**ADC Planning Consultation
Response from the Historic Buildings Adviser**

Application Number	AL/73/13/
Address	Barn, Sack Lane Dairy, Lidsey
Description	Conversion of barn into dwelling. Resub of AL/42/13.
Case Officer	Simon Davis
Site Visit	Previous

REVISION			
PROJECT			
Proposed conversion of existing barn at Sack Lane Dairy, Lidsey.			
SUBJECT			
Proposed Plans and elevations			
SCALE	DATE	DRAWING No	Rev
1:100	Mar 2013	2012 / 01 / 02	A
DRAWN	CHECKED

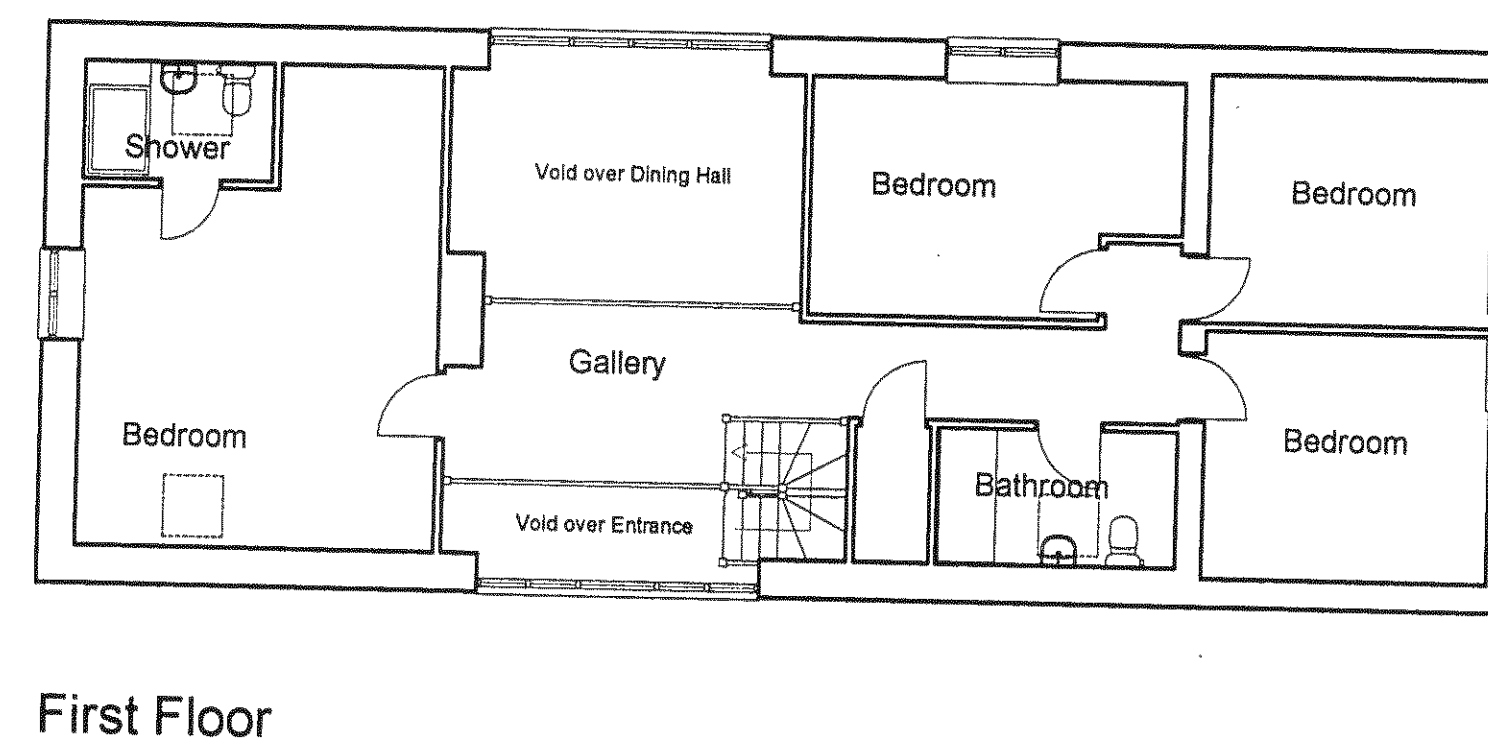
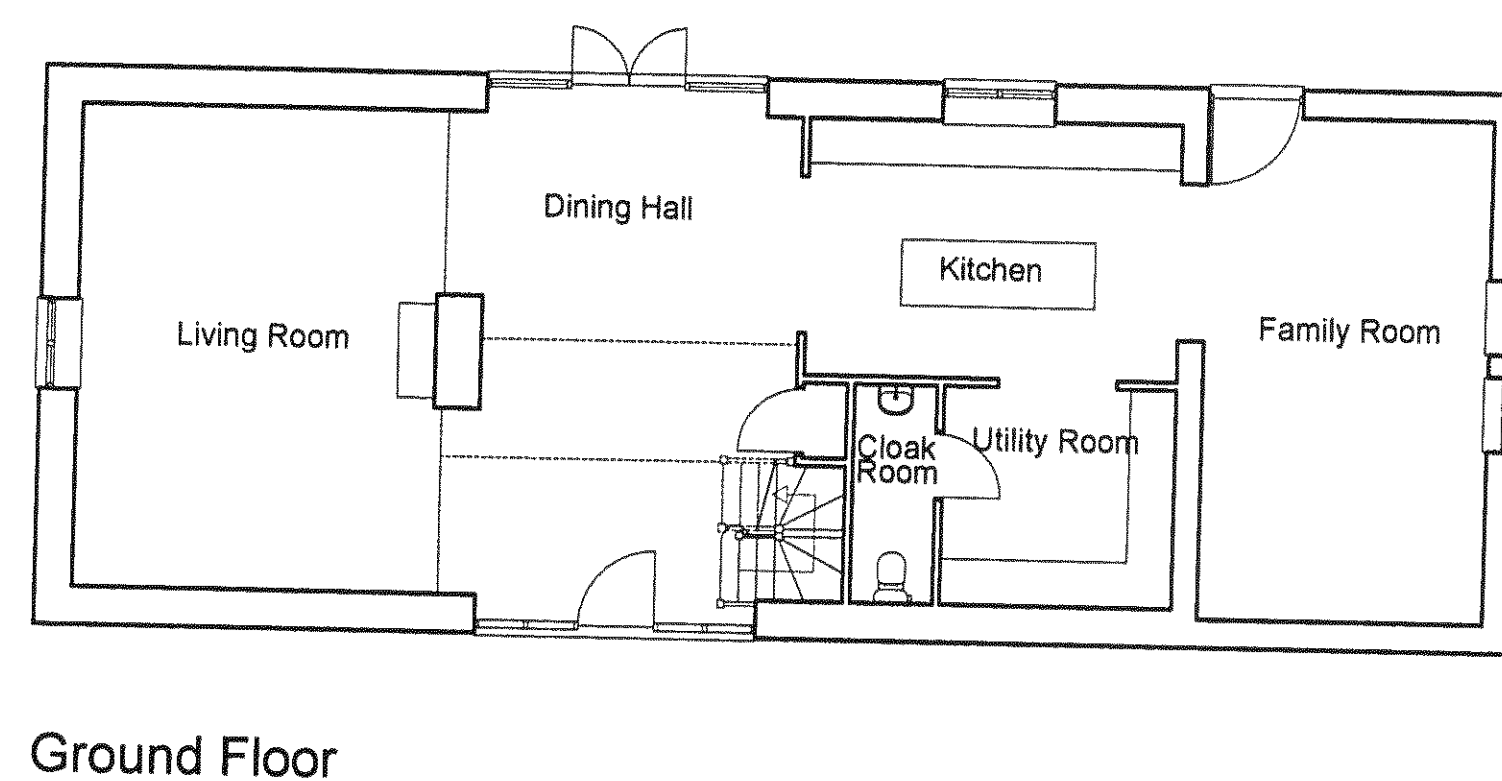
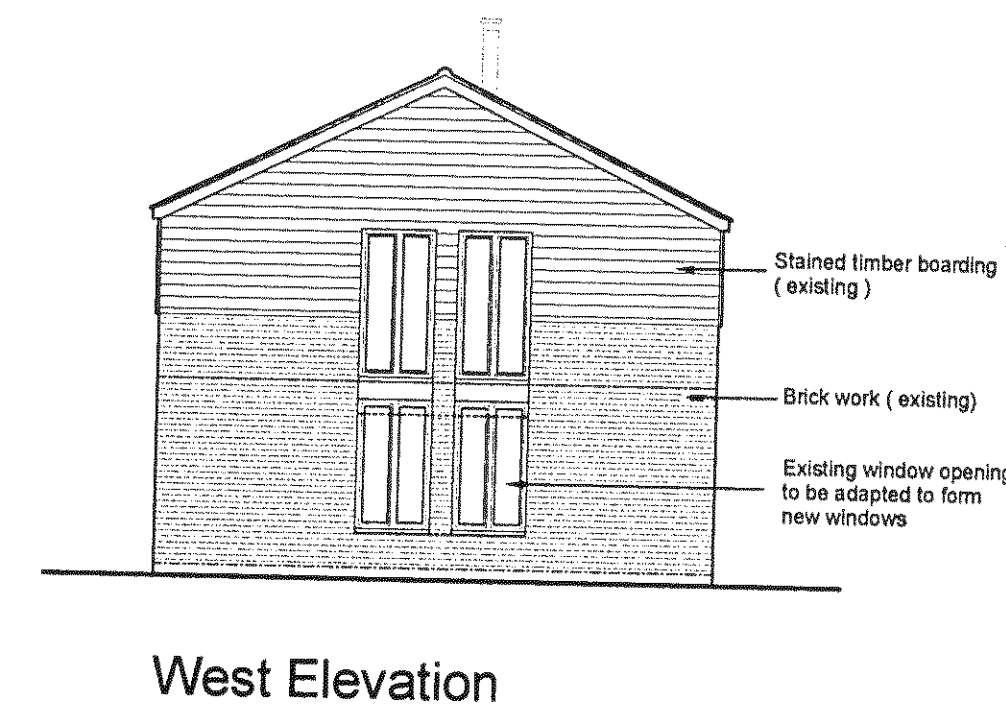
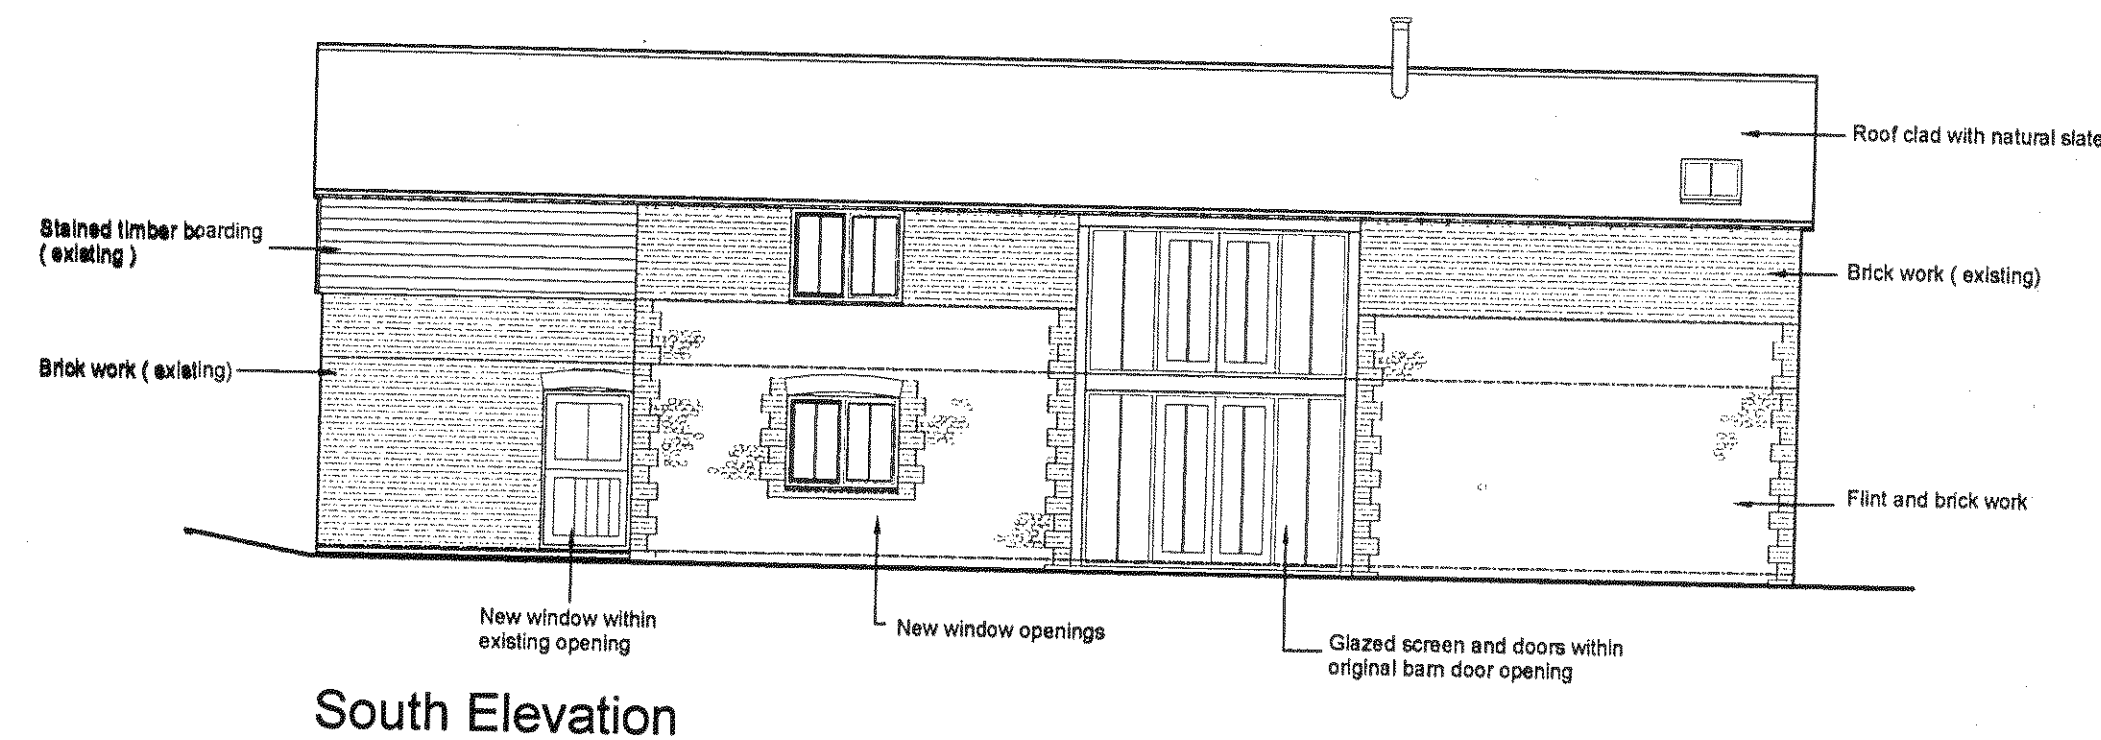
- Staircase: this encroaches into the main threshing space and should be moved so it is not visible in this way. It is also a turning stair which is not appropriate in an agricultural building and should be made straight.
- Windows: the windows on the east elevation appear slightly domestic in their form and might be improved by being extended down. The ground floor aperture could appear more like a door opening.
- Subdivision: the level of subdivision is excessive for a barn and should be reduced. The turning stair and downstairs WC both block light, whilst upstairs the walls prevent any experience of the space. This approach is not normally acceptable in barn conversions.
- Setting: the grass areas and paving leading up to the barn is overly domestic and suburban in nature. This is at odds with the agricultural context of the building and its appreciation. This should be simplified.

Please note that a potential solution to the subdivision issue might be to put the main living accommodation on the first floor. This would allow these rooms to be exposed to the roof and potentially create a more interesting space. It would also allow this floor to be more visually permeable (lower glass walls?) as well as lighter. The kitchen and living space could be more open-plan in this respect and not divided off into kitchen-utility-family room etc as shown.
